Your Ref: EN010012
Our Ref: 20026265

Application by NNB Generation Company (SZC) Limited for an Order Granting Development Consent for The Sizewell C Project

Submission in lieu of attendance at Issue Specific Hearing 6 (ISH6) on Coastal Geomorphology

DRAWING TITLE:
 TEMPORARY COASTAL DEFENCE FEATURE
 GENERAL ARRANGEMENT

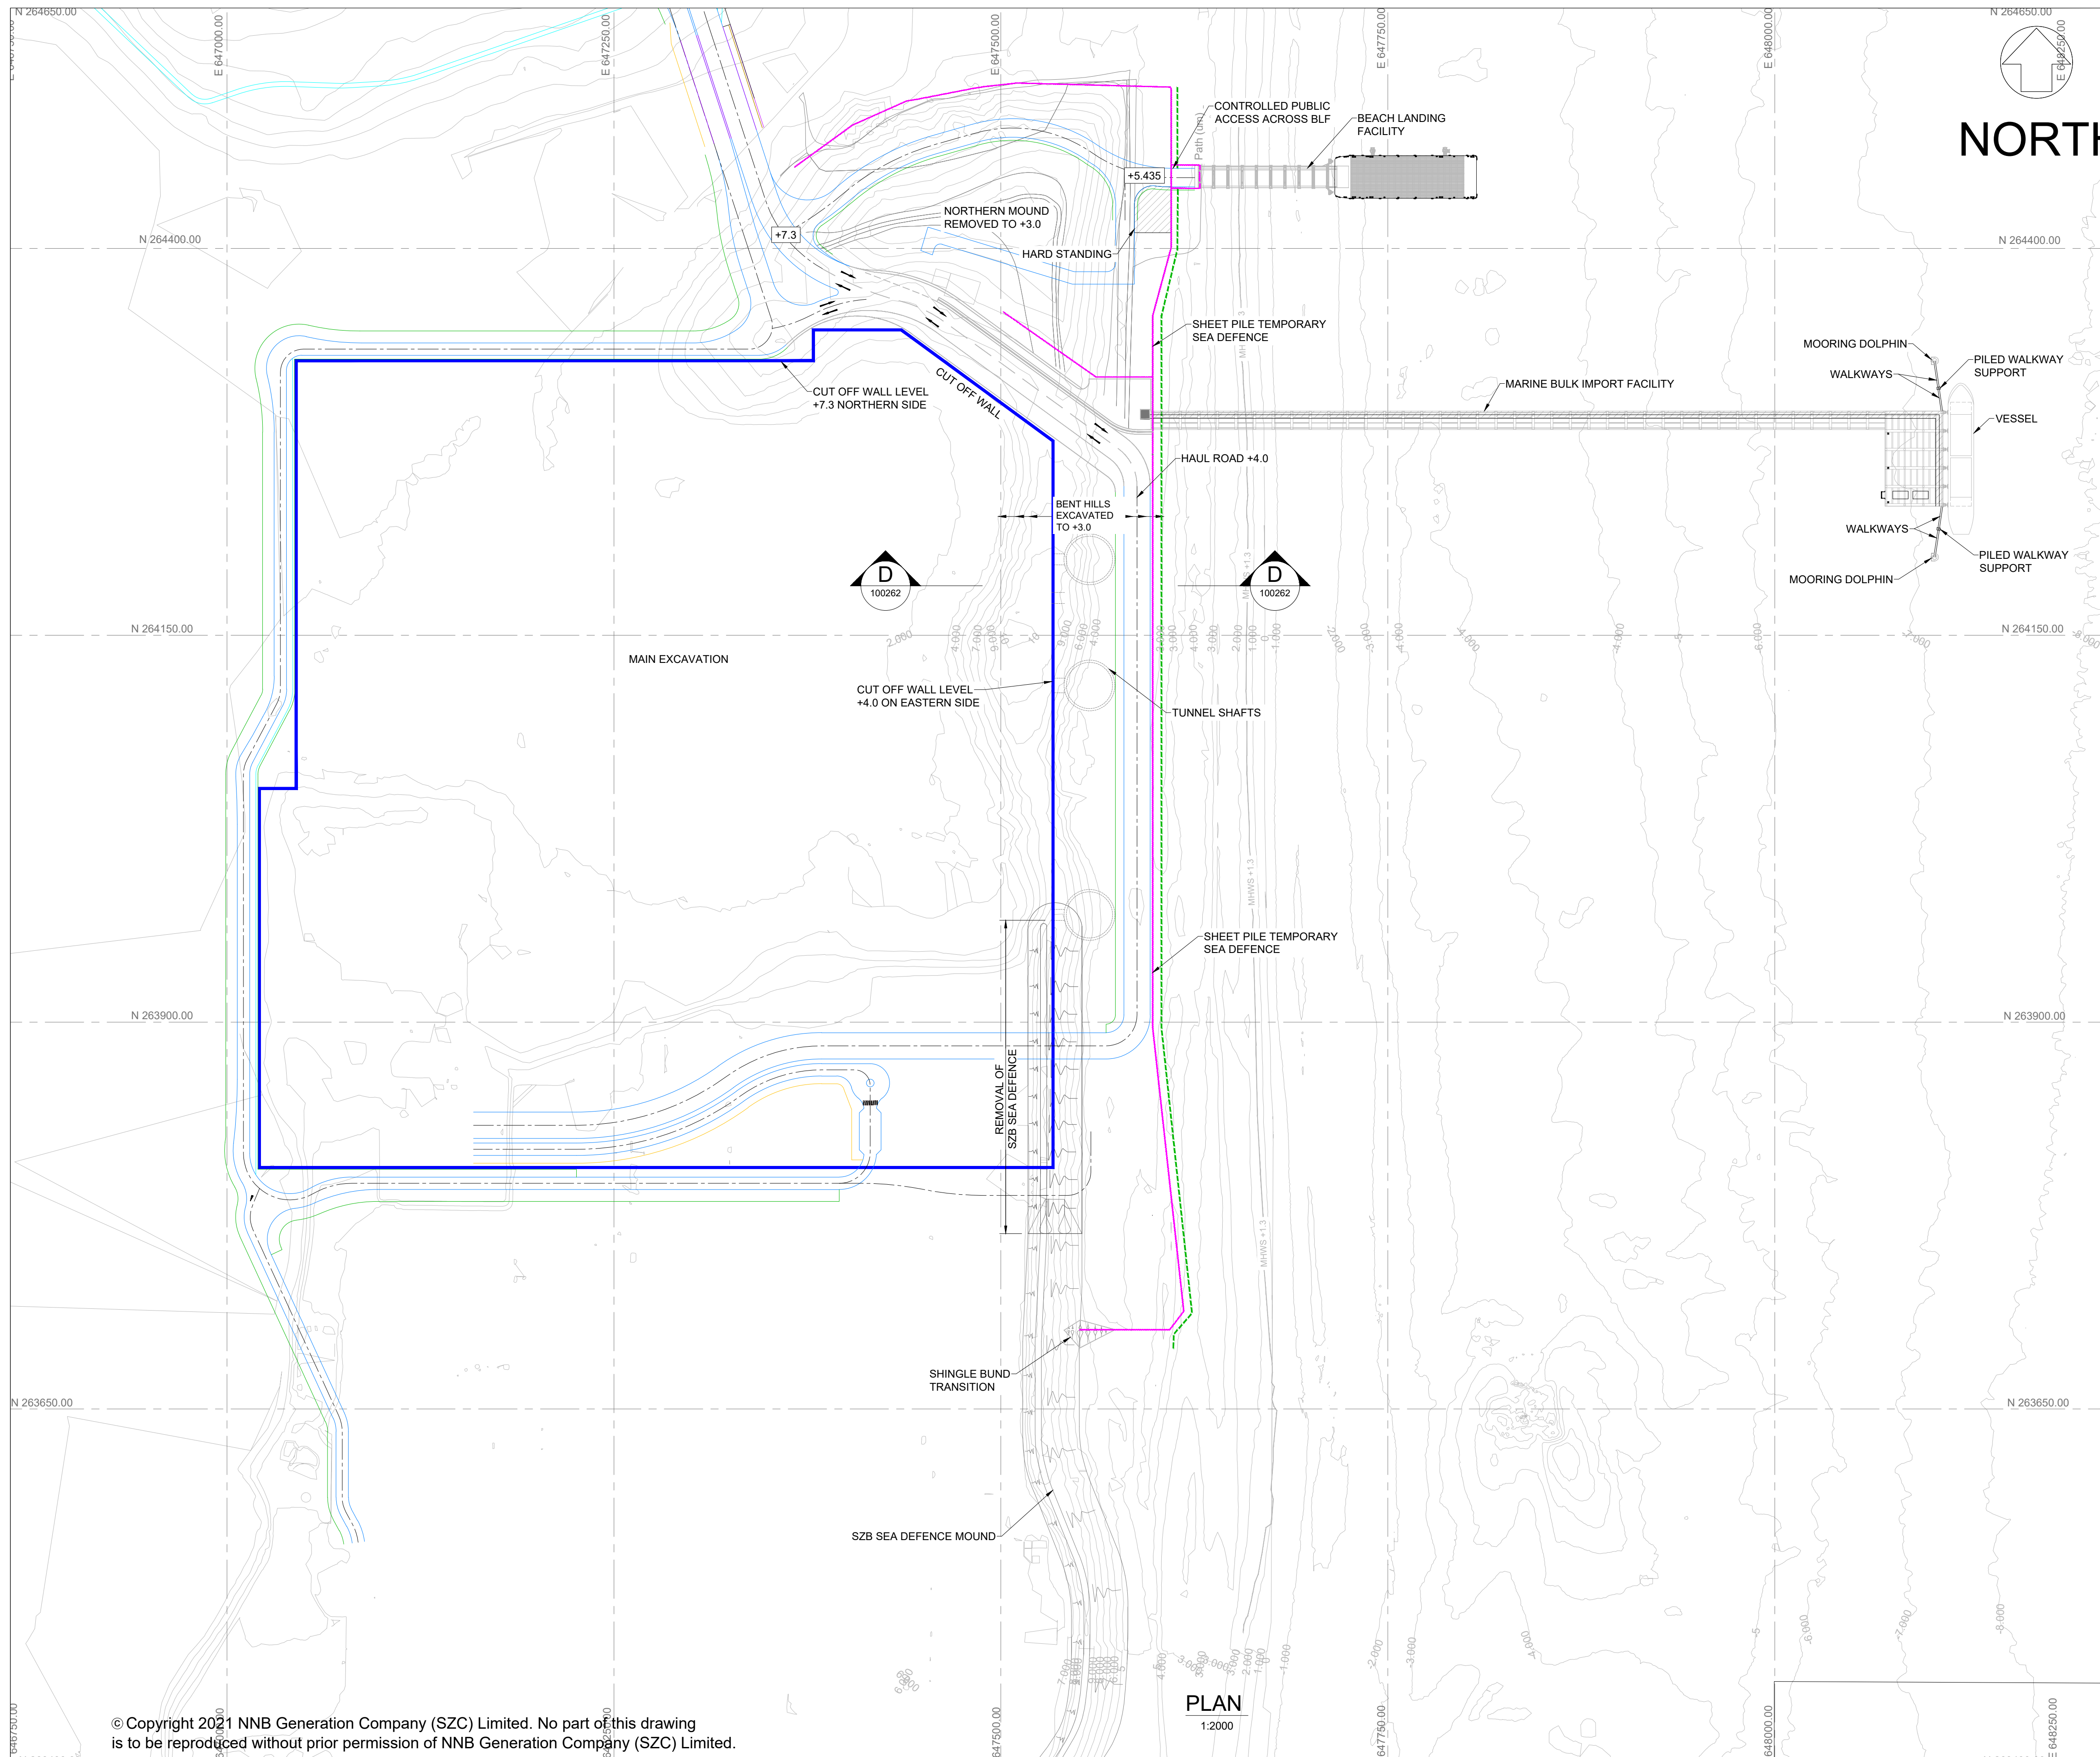
The Trust feels that the design for the HCDF should be complete by this stage of the examination into a development of such significance. The Trusts feels that the discussion of coastal process and geomorphology topics at an Issue Specific Hearing without the provision of full details of the HCDF limits the scope of detail that can be covered. We are conscious that this may mean the applicant defers answering relevant questions in this hearing to the submission of yet further information later in the examination. We would welcome an opportunity to provide responses on the additional detail of the HCDF once it is forthcoming and accompanied by all relevant assessments.

DRAWING TITLE:
 PERMANENT COASTAL DEFENCE FEATURE
 GENERAL ARRANGEMENT

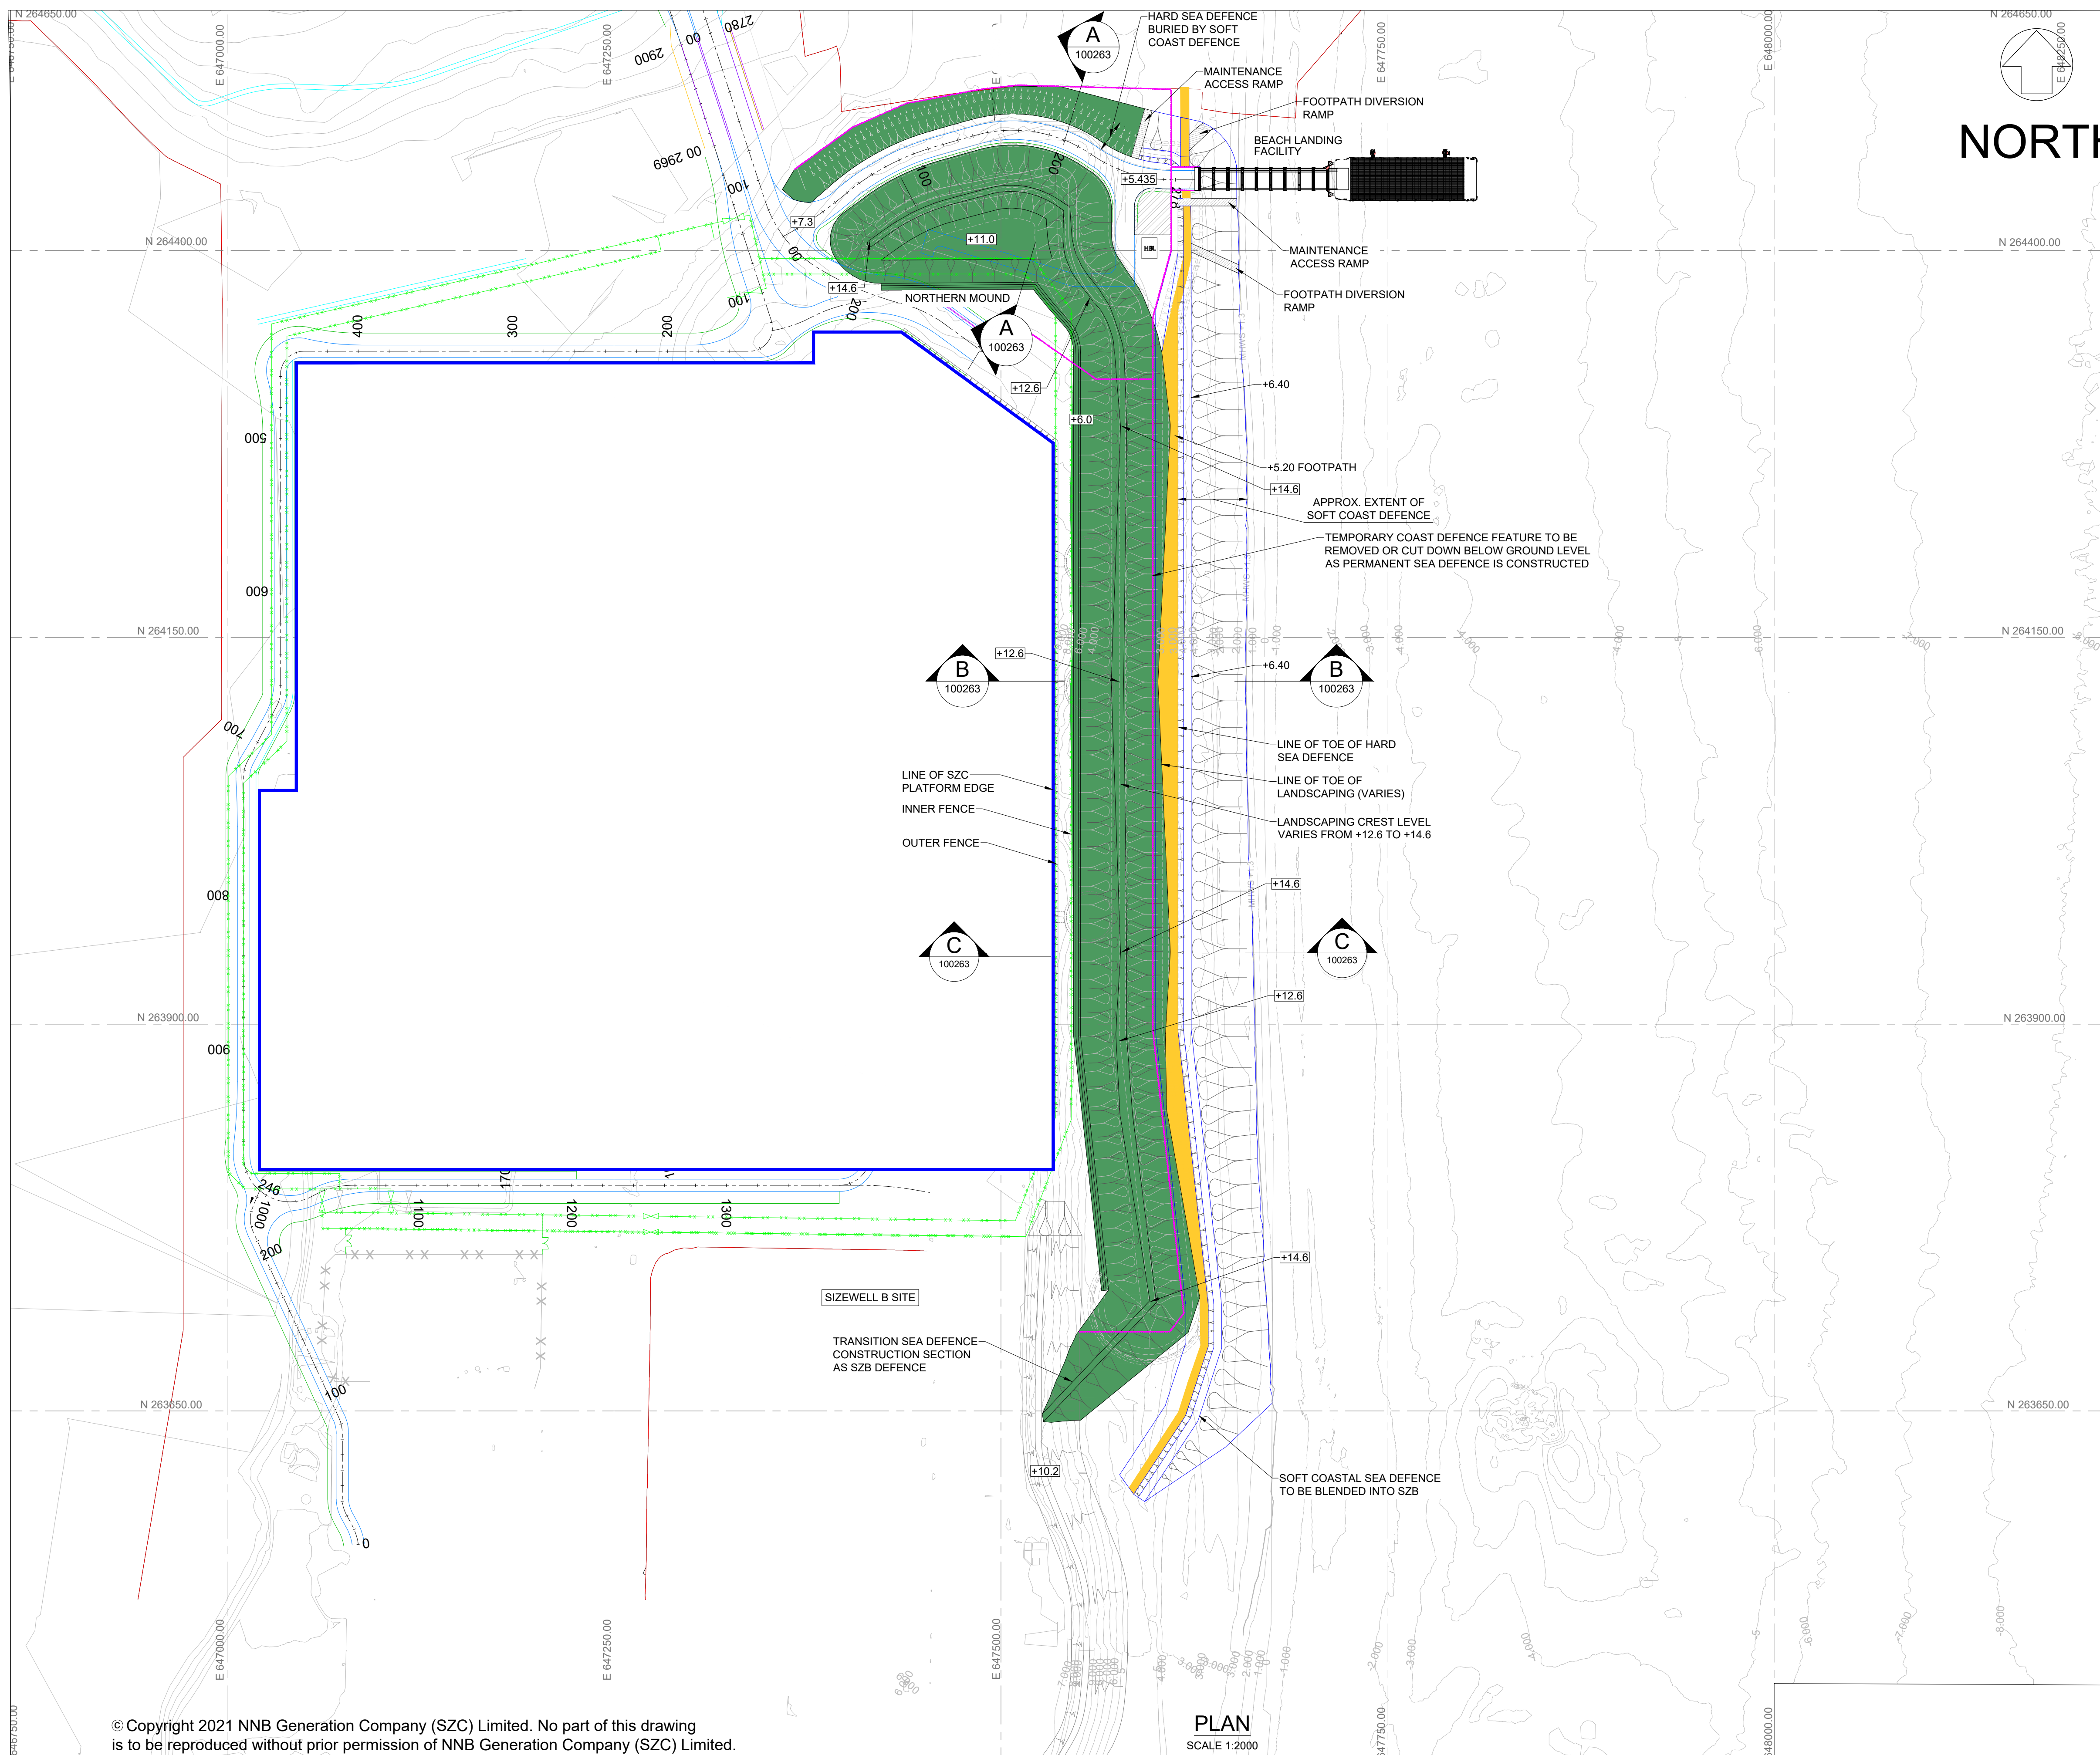
As highlighted in our Written Representation (see paragraphs 10.6 to 10.11) the National Trust believes the more seaward position of the HCDF and SCDF for Sizewell C are in conflict with the SMP.
